## Table of Amendments to the Development Consent Order (DCO)

**Wheelabrator Kemsley (K3 Generating Station) and Wheelabrator Kemsley North (WKN) Waste to Energy facility Development Consent Order**

PINS Ref: EN010083

Document 2.7  
June 2020 - Deadline 6 Submission

Client **Wheelabrator Technologies Inc**
 Project **K3 and WKN DCO**
 Title **WKN Parameter Plan**

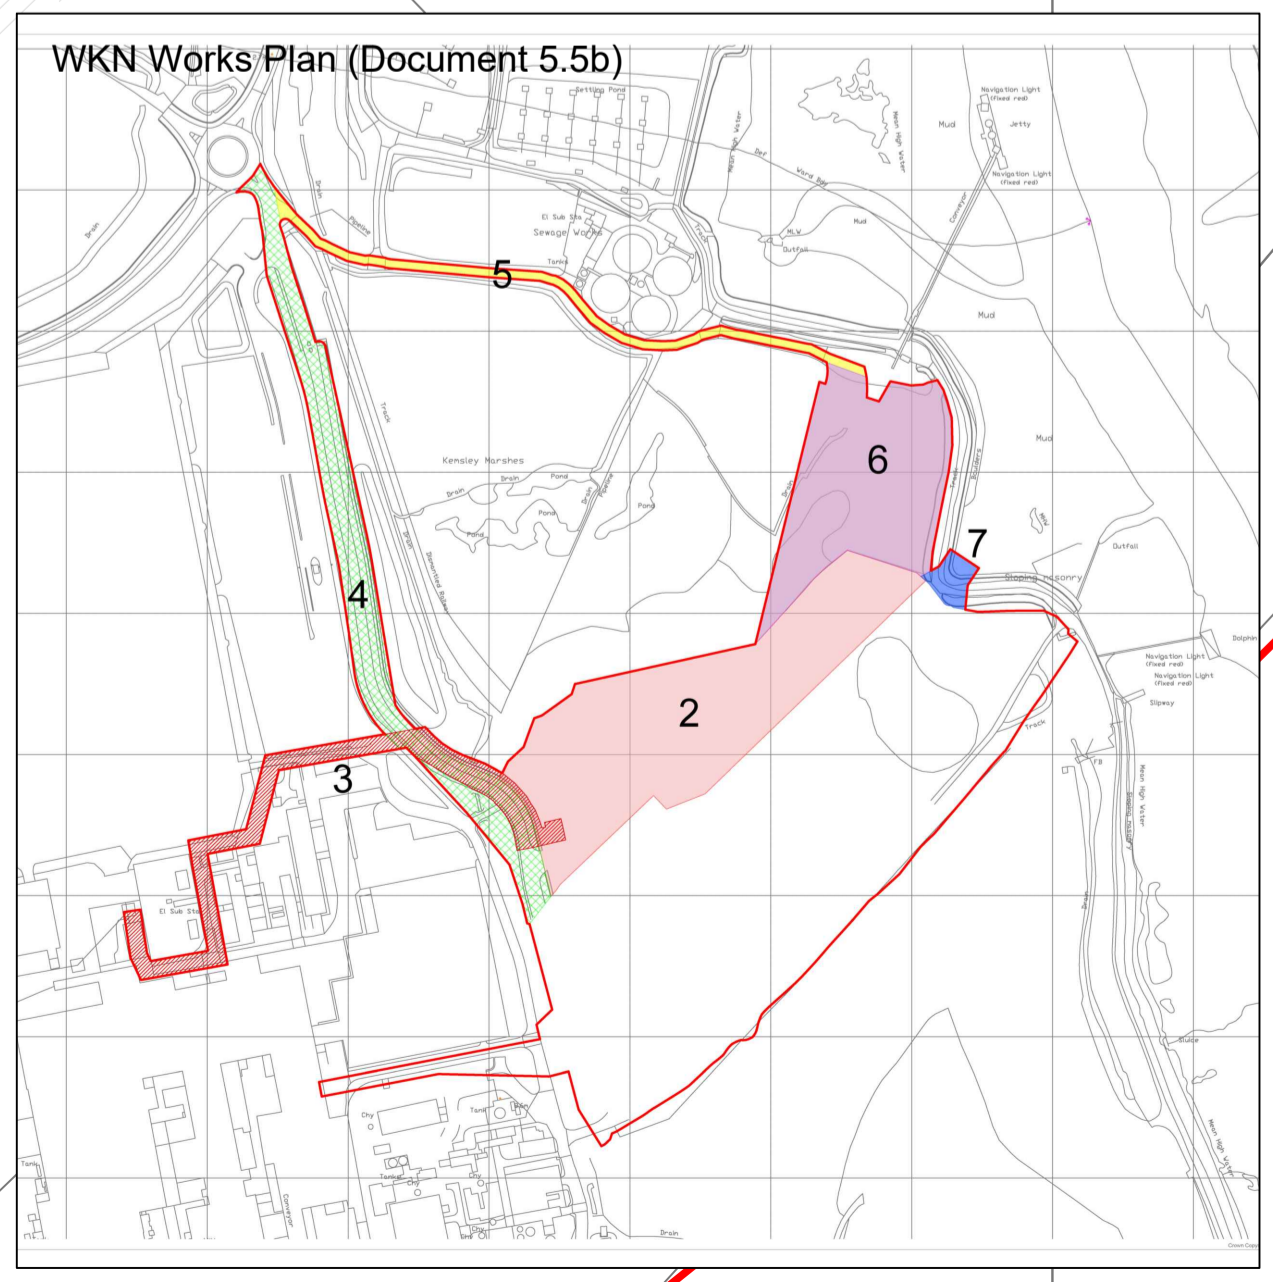
Schedule 2 Requirement 14(4) Detailed Design Approval	Duplication of "(4)" deleted.  Definition of "WKN parameter plan" moved to requirement 1.	Amended in response to the ExA's question ISH30.
Schedule 2 Requirement 14 Detailed Design Approval – Table 1	The maximum height of Work No 2(j) Administration Office has been corrected to 30m to be consistent with Table 2.3 of the ES.	Amended in response to the ExA's first written questions 1.2.4.
Schedule 2 Requirement 16(4) Implementation and maintenance of landscaping	Reference to the 'annual landscaping maintenance plan' has been corrected to the 'approved landscaping scheme'.	Amended in response to the ExA's question ISH31.
